October 5, 2022

Molly McGuire
Assistant Planner
Community Planning & Development
City of Mercer Island
9611 SE 36th Street
Mercer Island, WA 98040
Molly.McGuire@mercerisland.gov

**RE: Comment Letter for Proposed Demolition and Rebuild of 6950 SE Maker Street
Permit No. 2207-019**

NOTES

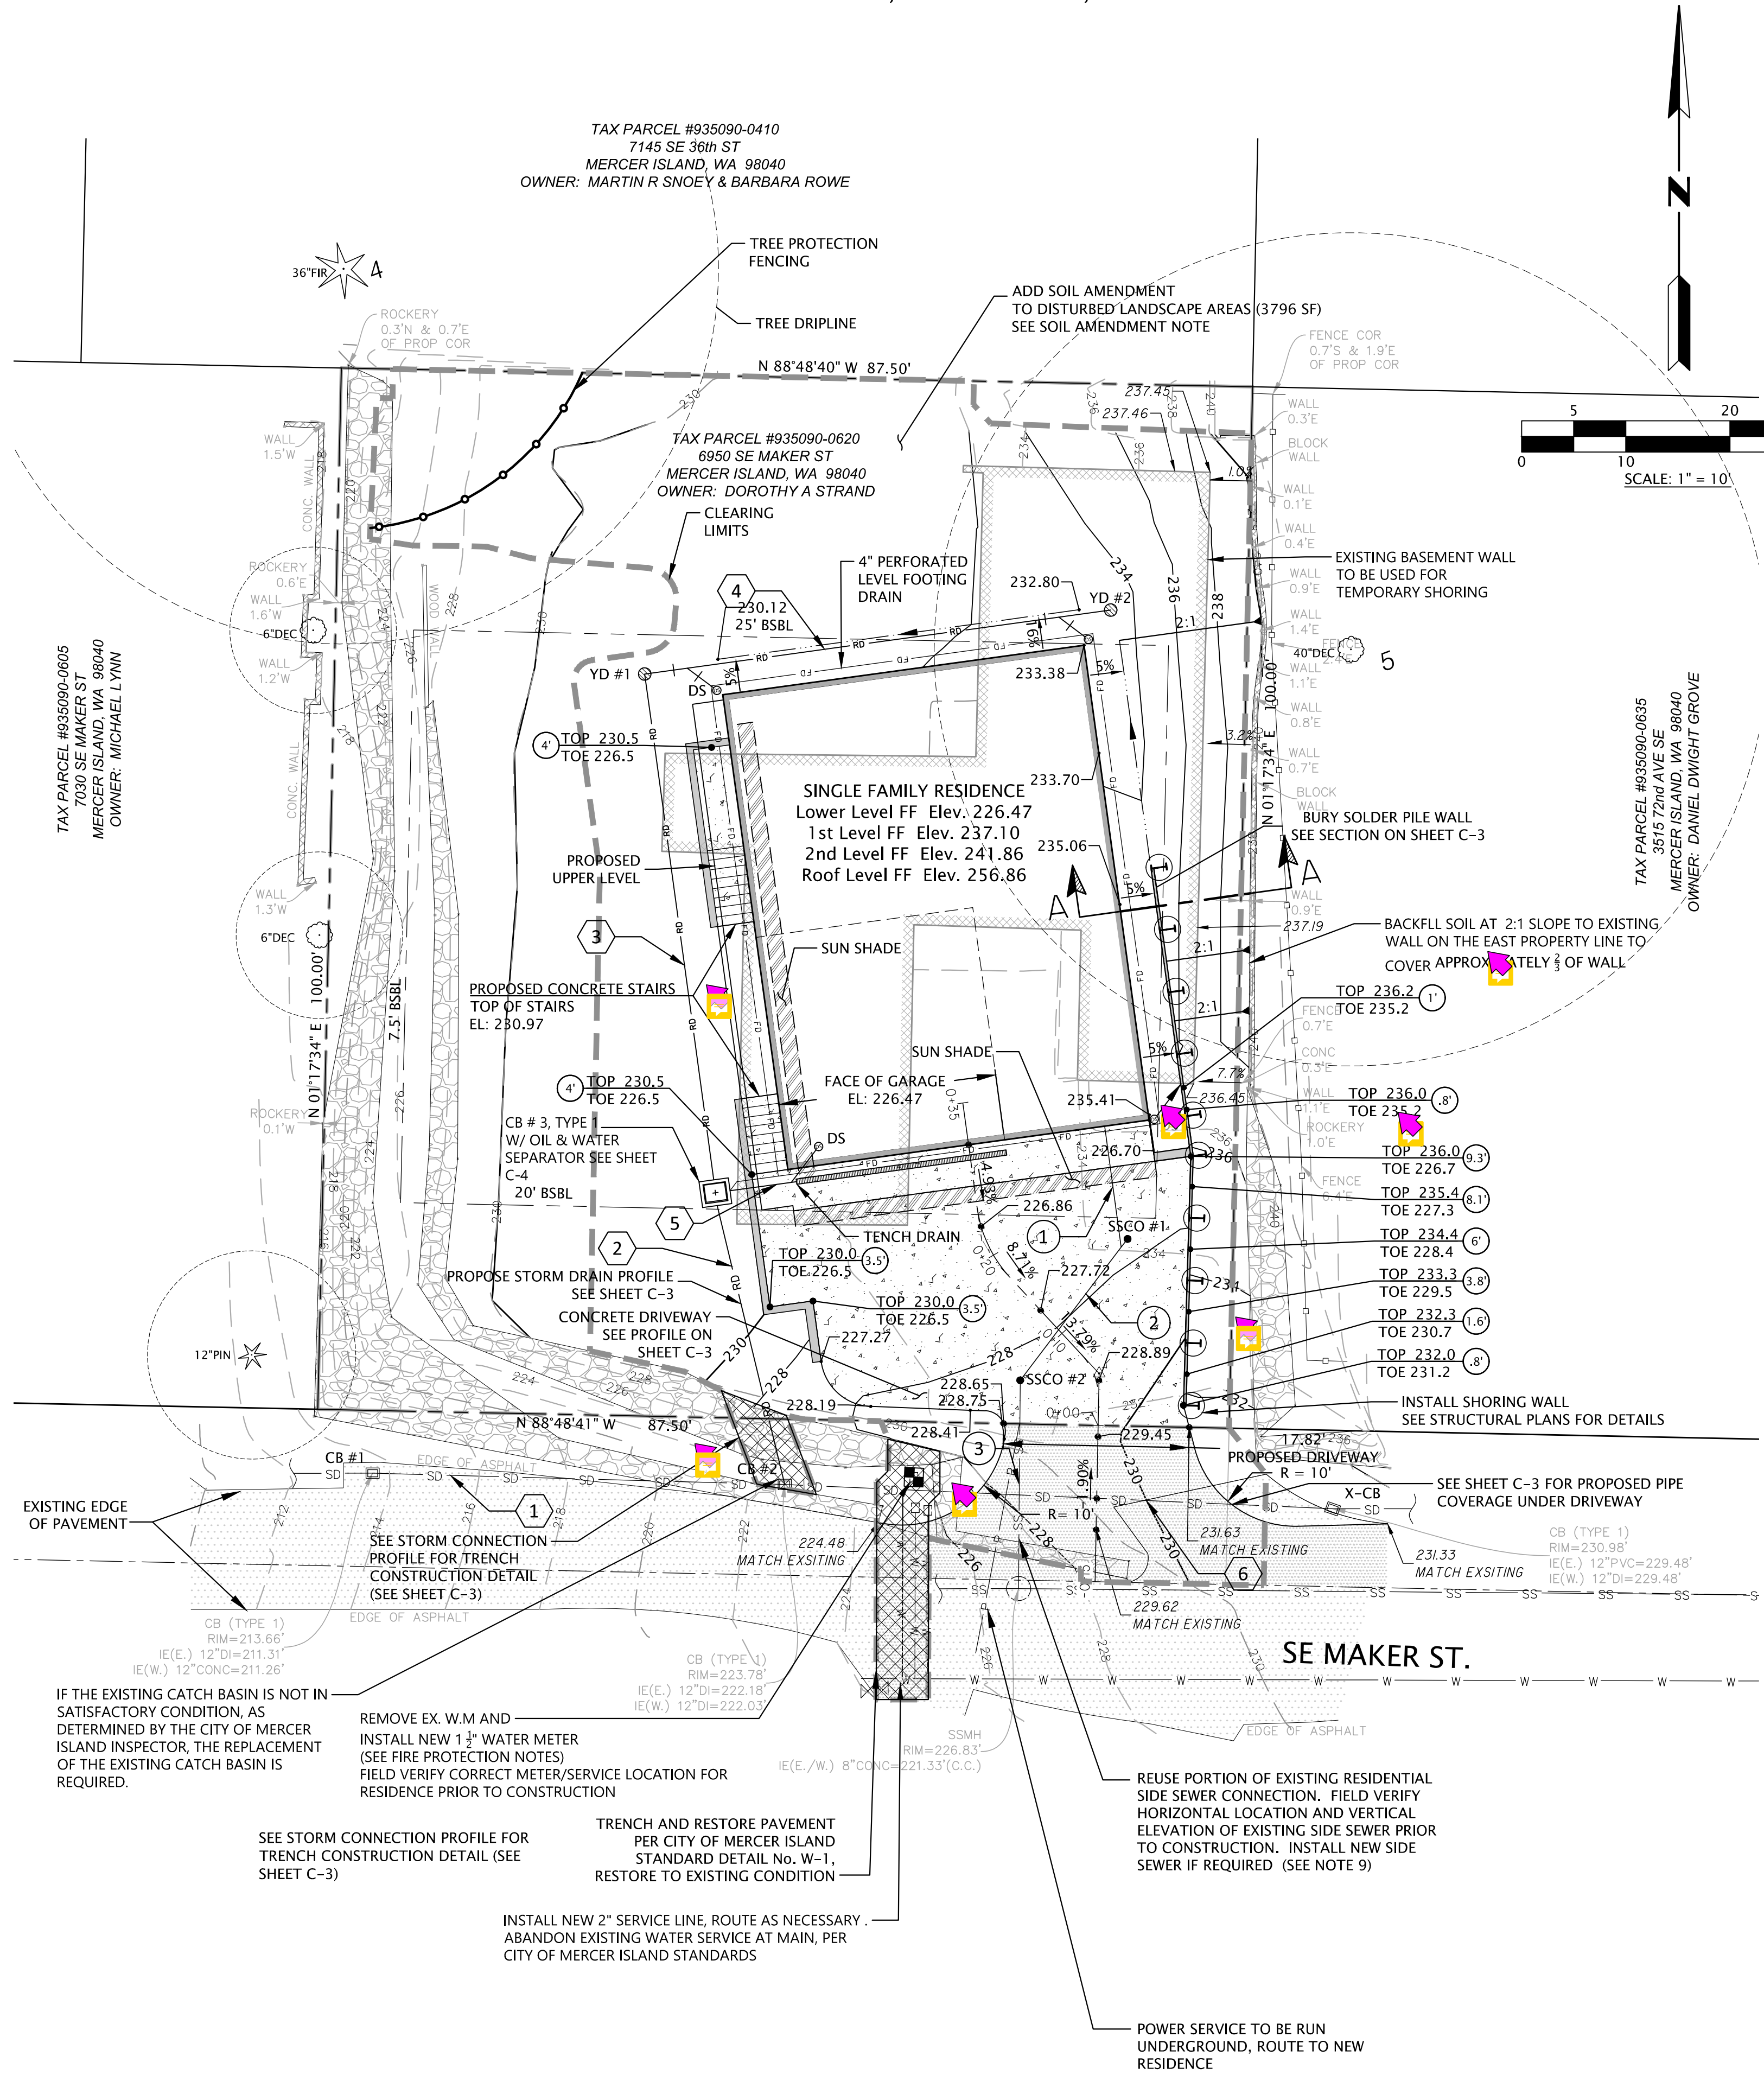
- No filling should take place above the existing grade to the west of the new residence in order to avoid decreasing stability of the filled area further;

- No fill or substantial disturbance (including clearing, utility installation, or construction staging) within 20 feet of the existing western rockery;

- No new structures, including patios or decks should be constructed west of the new residence;
- No staging of materials for construction should occur west of the residence footprint;

- The proposed structure should be within the prescriptive minimum 25-foot buffer for shallow seated landslide areas, unless slope issues are mitigated and then the residence should be 20 feet from the western rockery,

The Geotech Study states that “detailed plans were not available at the time” of the Geotech Study.⁶ And, to date it is unclear from the permit plans whether additional analysis of the detailed project plans took place. For instance, parts of the proposed structure are closer than the 25 foot (and even the 20 foot) recommended buffers, and construction and staging will likely occur within the west side of the project. It is also unclear whether an adequate slope stabilization system will be implemented.
